21 June 2021

Application No: SSD-10822510

Re: Randwick City Council submission on the State Significant Development SSD-10822510 – UNSW Health Translation Hub (SSD-10822510)

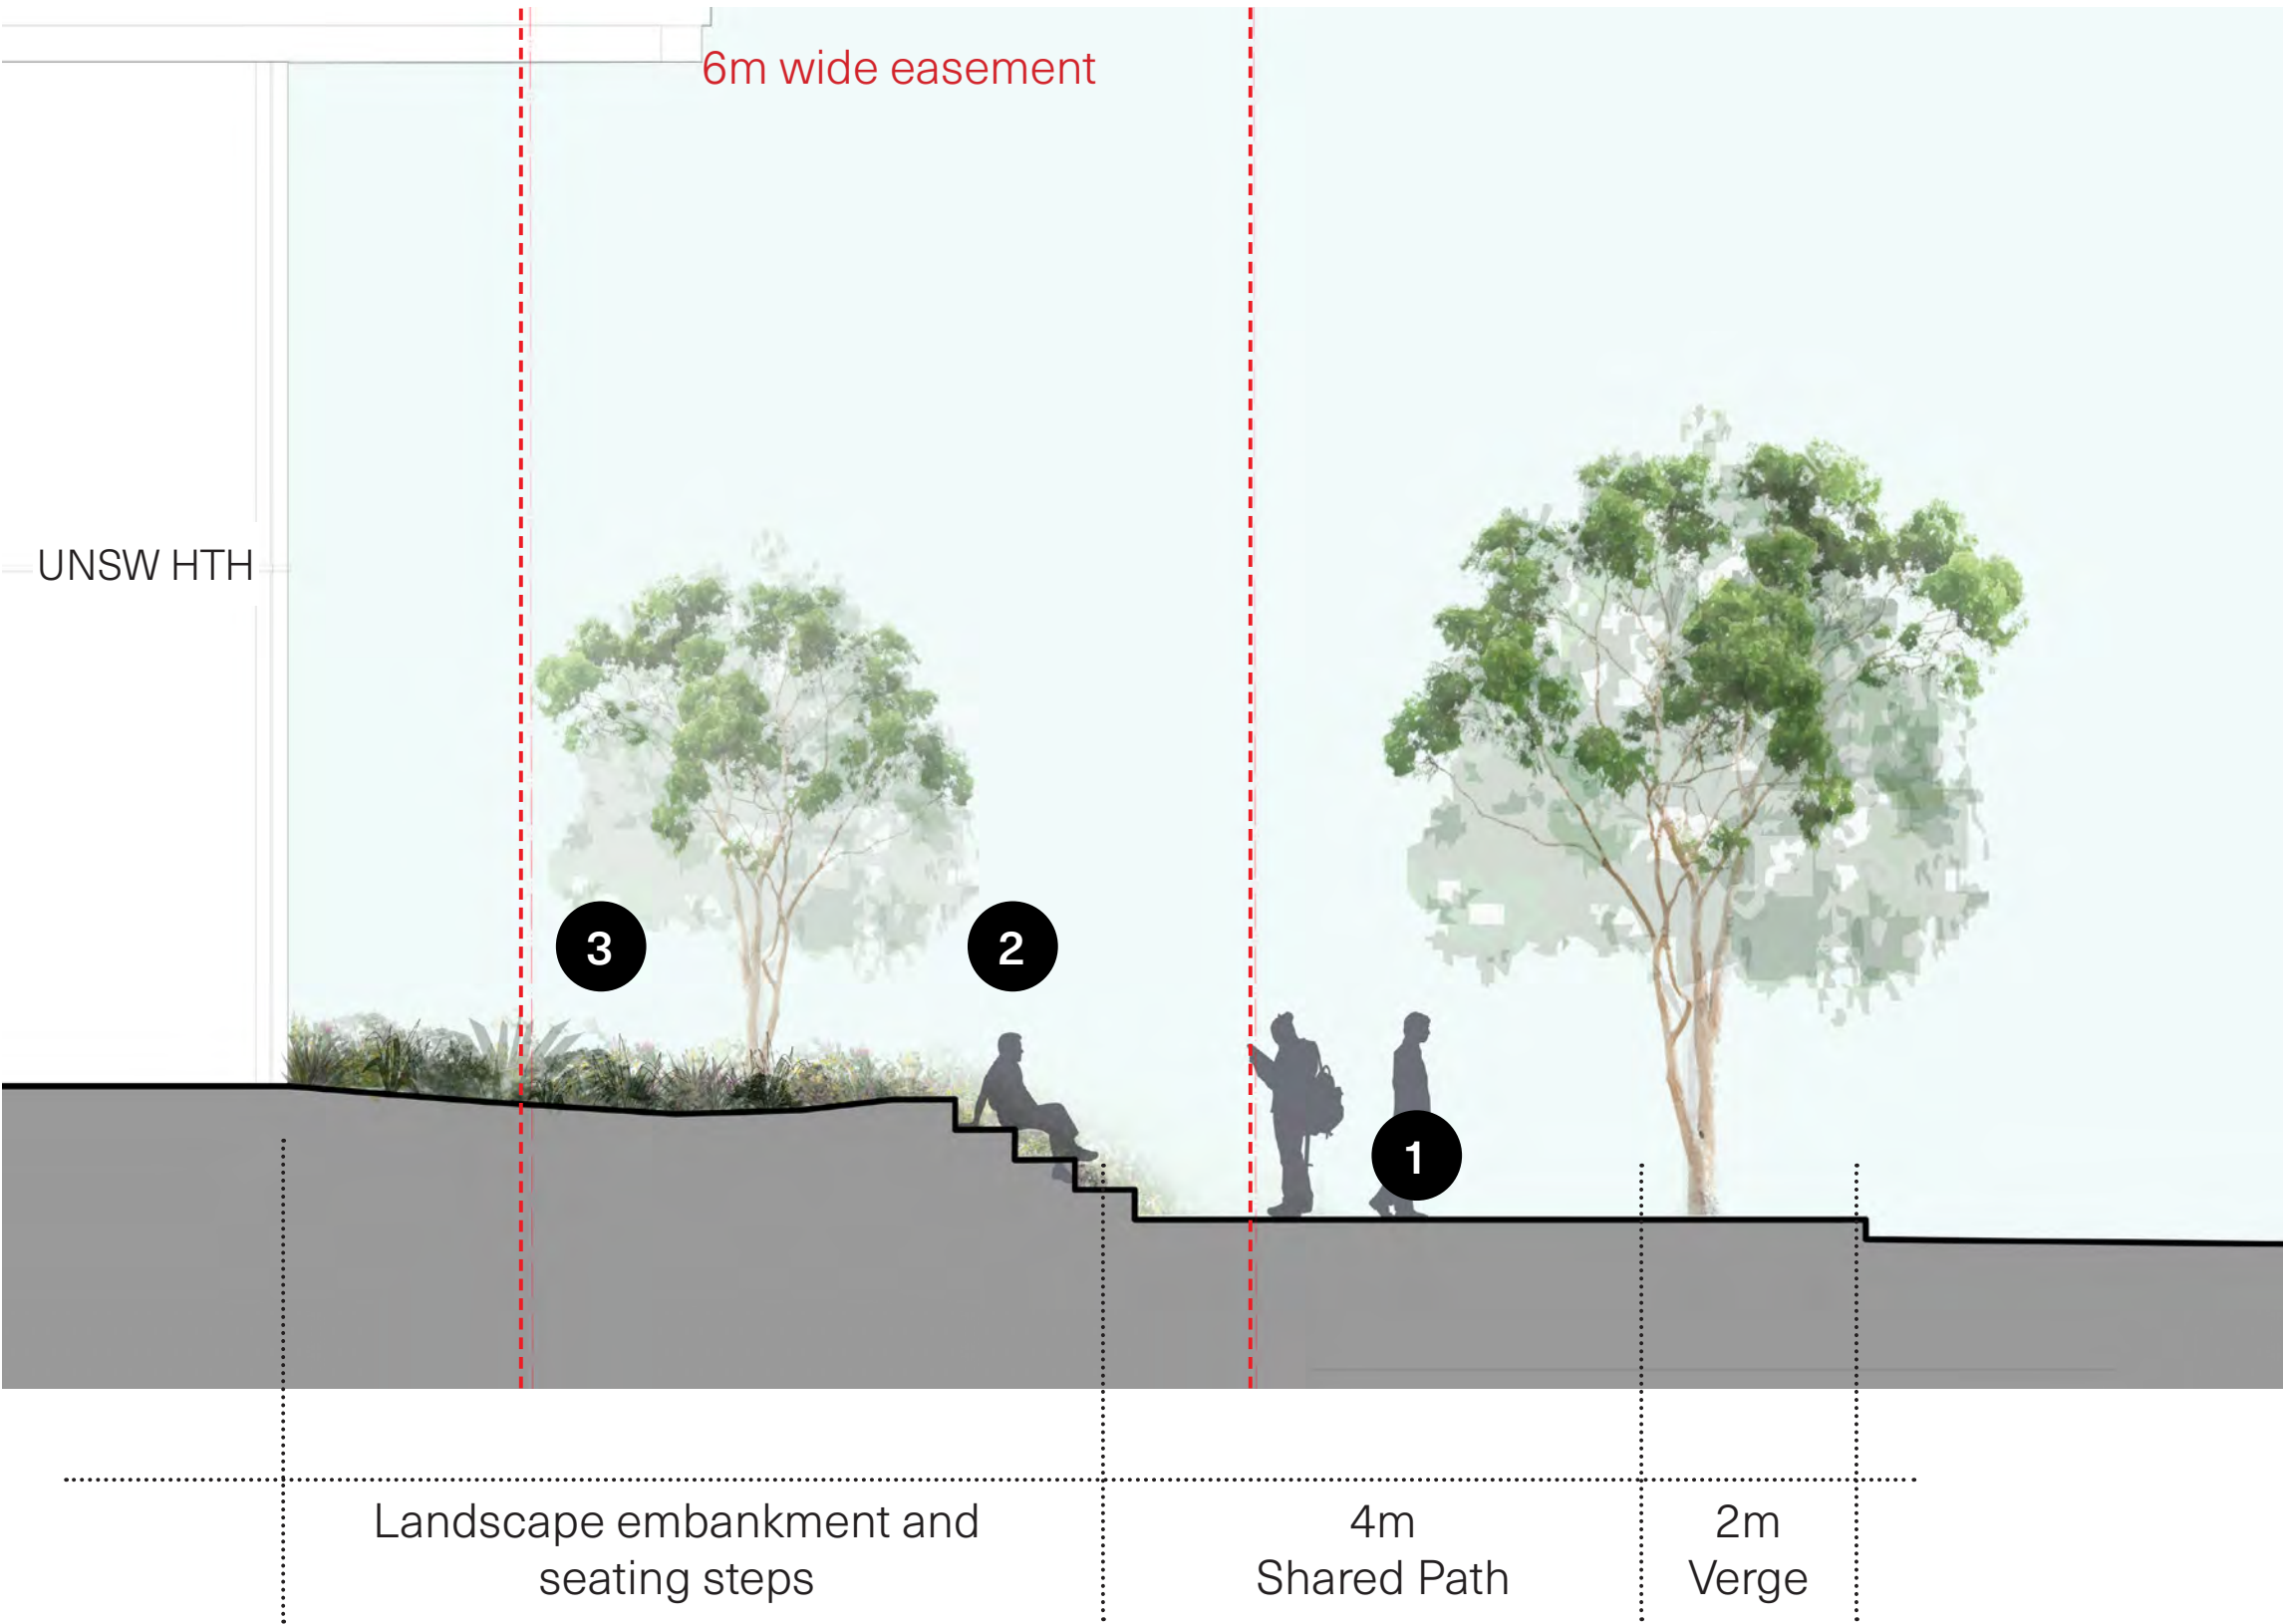
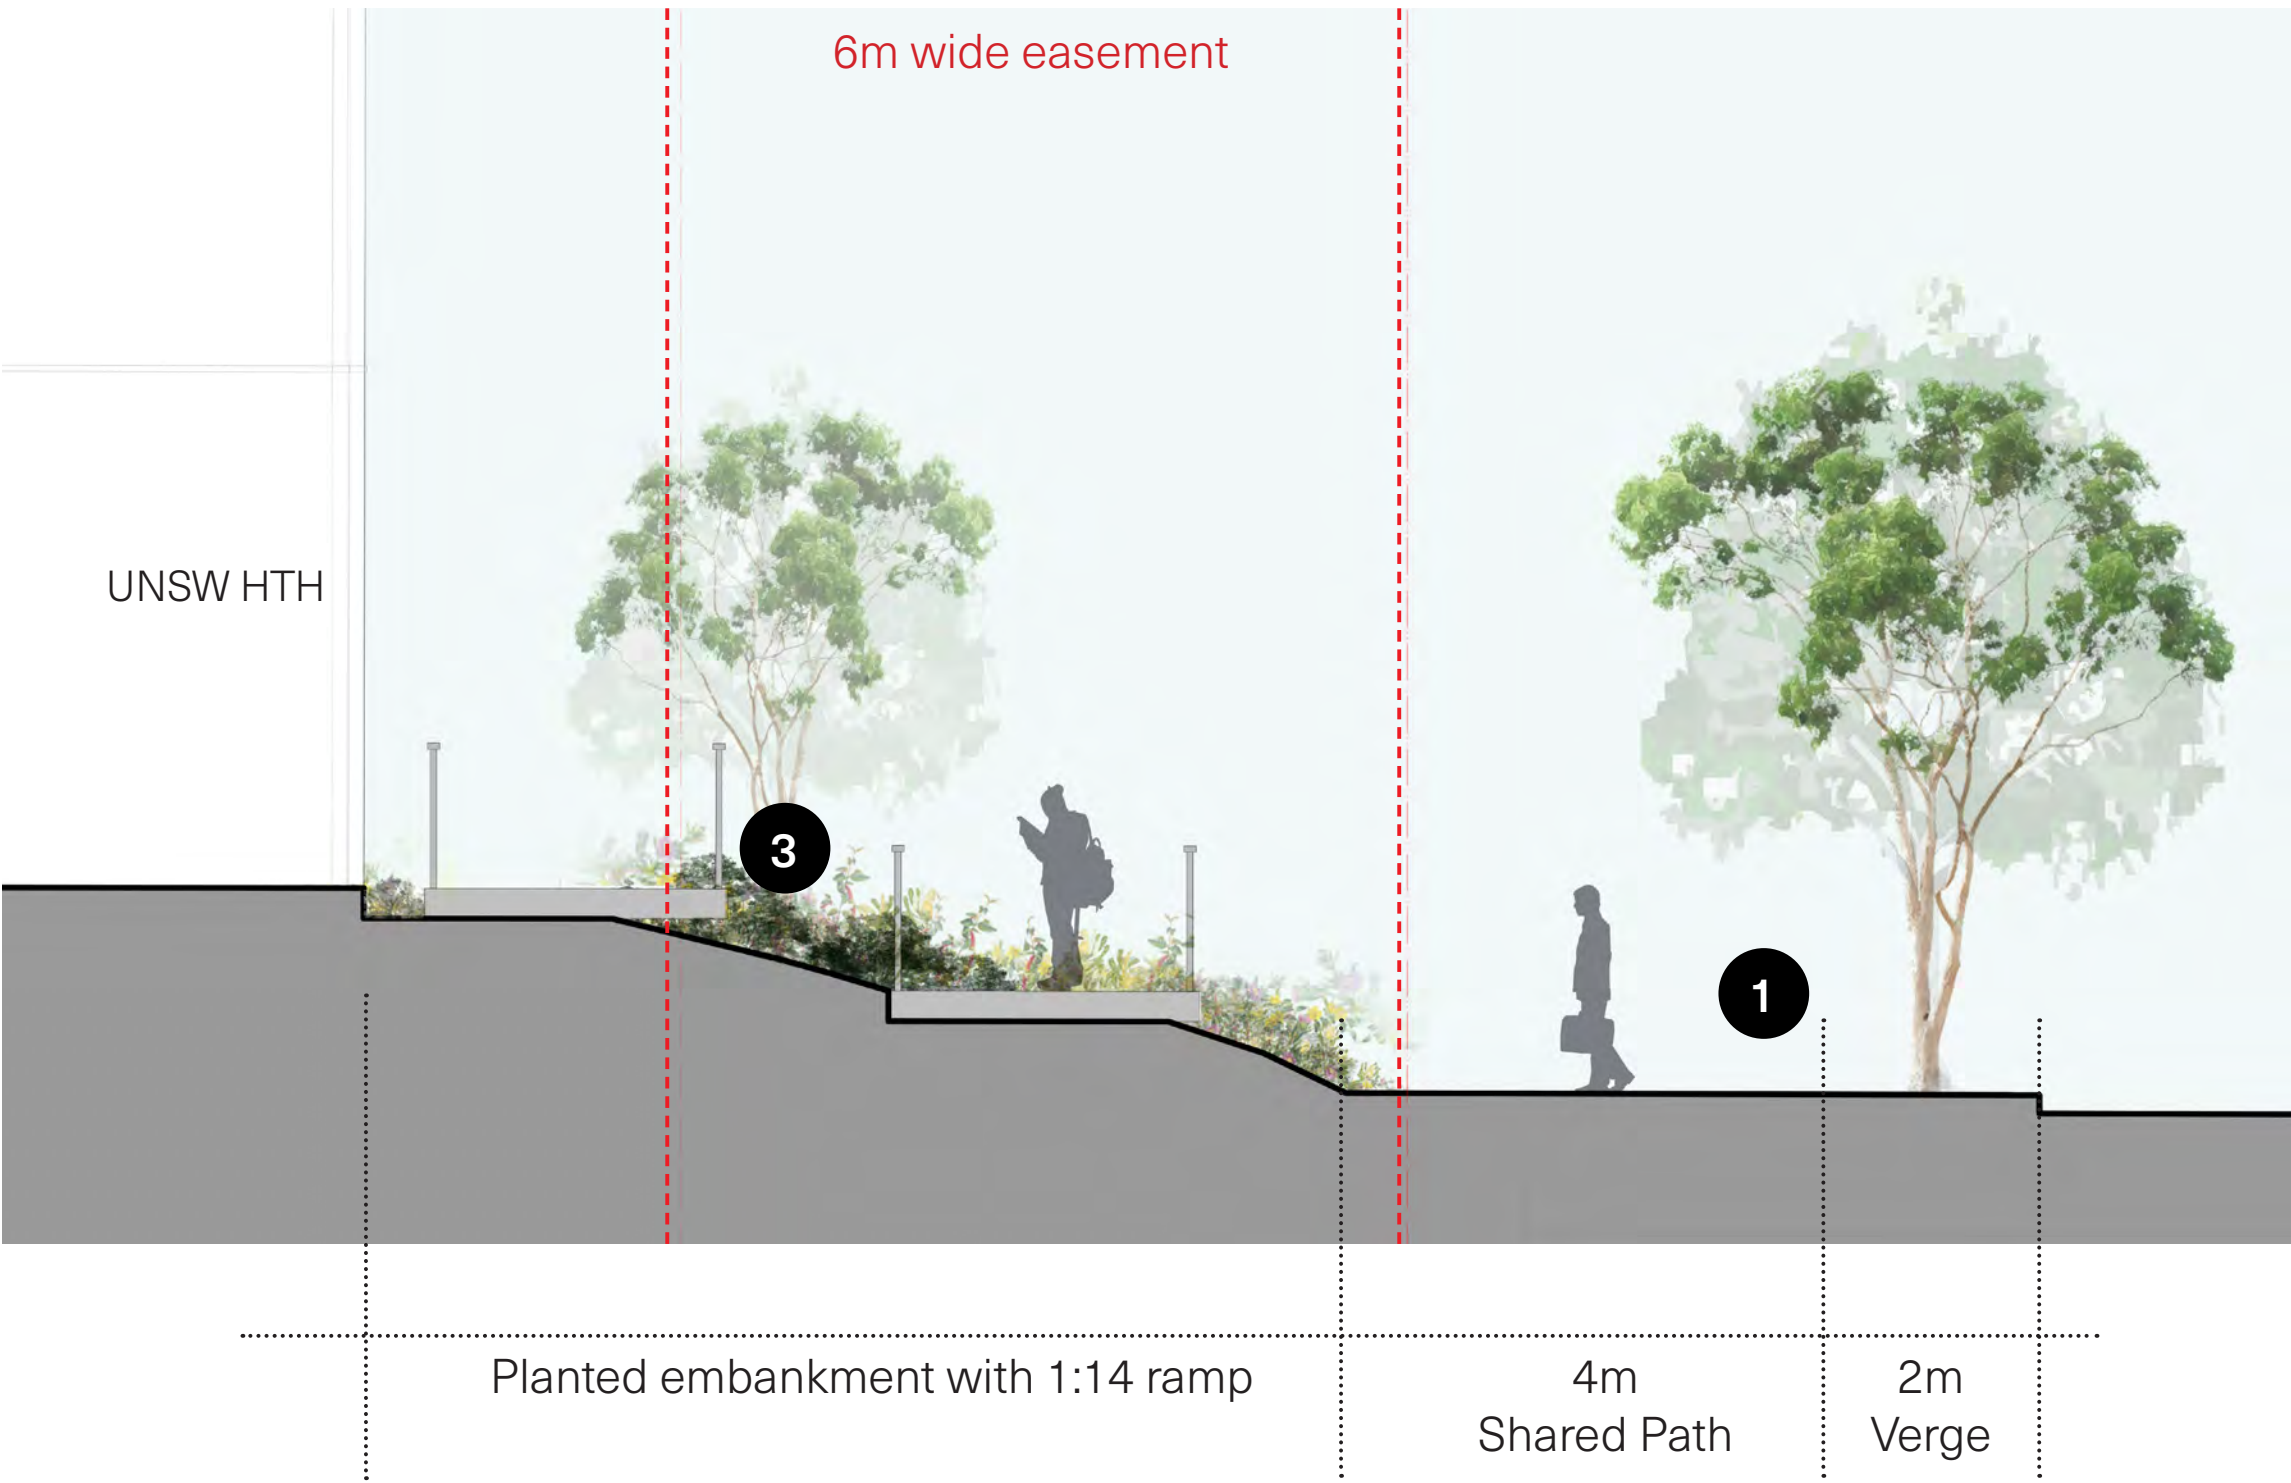
25. The indicative street trees and pavement level planting along the Botany Street and High Street frontages within Councils road reserve currently have a formal generic character. In contrast, the landscaping for the UNSW HTH site is inspired by the coastal dune system. A coordinated landscape outcome that picks up some of the sand dune planting themes along this section of the High Street streetscape would be beneficial. Council recommends coordination between Randwick City Council's Public Domain team and the proposals Landscape Architect moving forward.
